Client	Hawthorn
Project	Portland, ME
Lead Designer	
Production Manager	Jason DiOrazio
Production Staff

Revision #	Sheet	Description of Change
9	A0.0	Added revision 9 to title block
9	A2.1	Linen room 179 updated to Mech Room. Layout of Storage 180 revised to include Janitor's sink
9	A3.2	Linen room 179 updated to Mech Room, notes added accordingly. Layout of Storage 180 revised.
9	A5.1	Detail 13 added to show layout of Mechanical/Storage rooms
9	M1.1	Linen room 179 updated to Mech Room. Detail 2 enlarged plan added to sheet for relocation of water heaters
9	M1.5	Plan updated accordingly to accommodate relocation of water heaters from room 177 to 179
9	M2.2	Details 1 and 2 updated per relocation of water heaters
9	M2.3	Detail 1 updated to show layout of Mech room without water heaters
9	M3.6	Plan updated to accommodate relocation of water heaters. Ductless split & exhaust fan added to room 179
9	M3.8	Plan updated to show location of water heater vents on roof
9	E1.5L	Lighting revised in new Mechanical room 179

ENLARGED MECHANICAL PLAN
E1.5P SCALE: 1/4" = 1'-0"

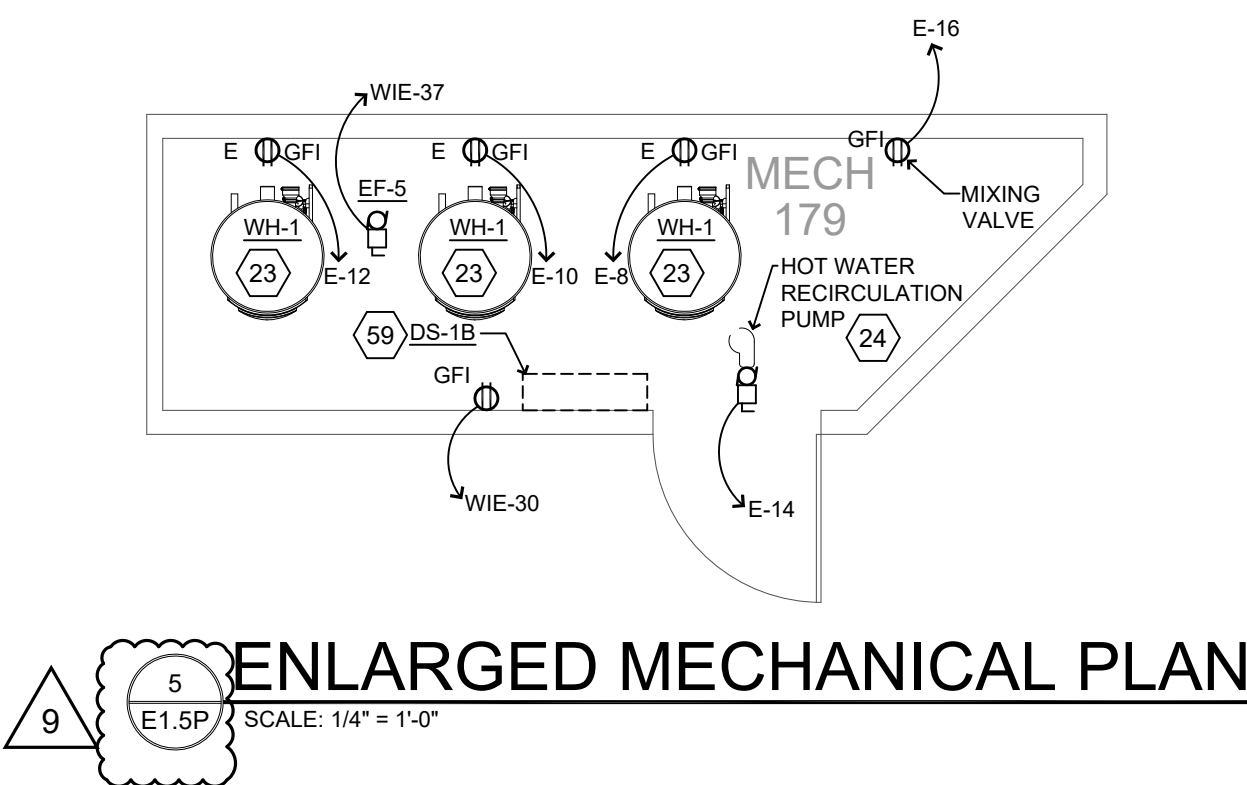
9	E1.5P	Enlarged detail 5/E1.5P added to sheet to show power layout in new Mechanical room 179
9	E2.2a	One Line Diagram updated. Detail 2 updated to show fire pump controller and no water heaters in Mech room 177.
9	E2.3a	Electrical panels updated
9	E2.3c	Electrical panels updated
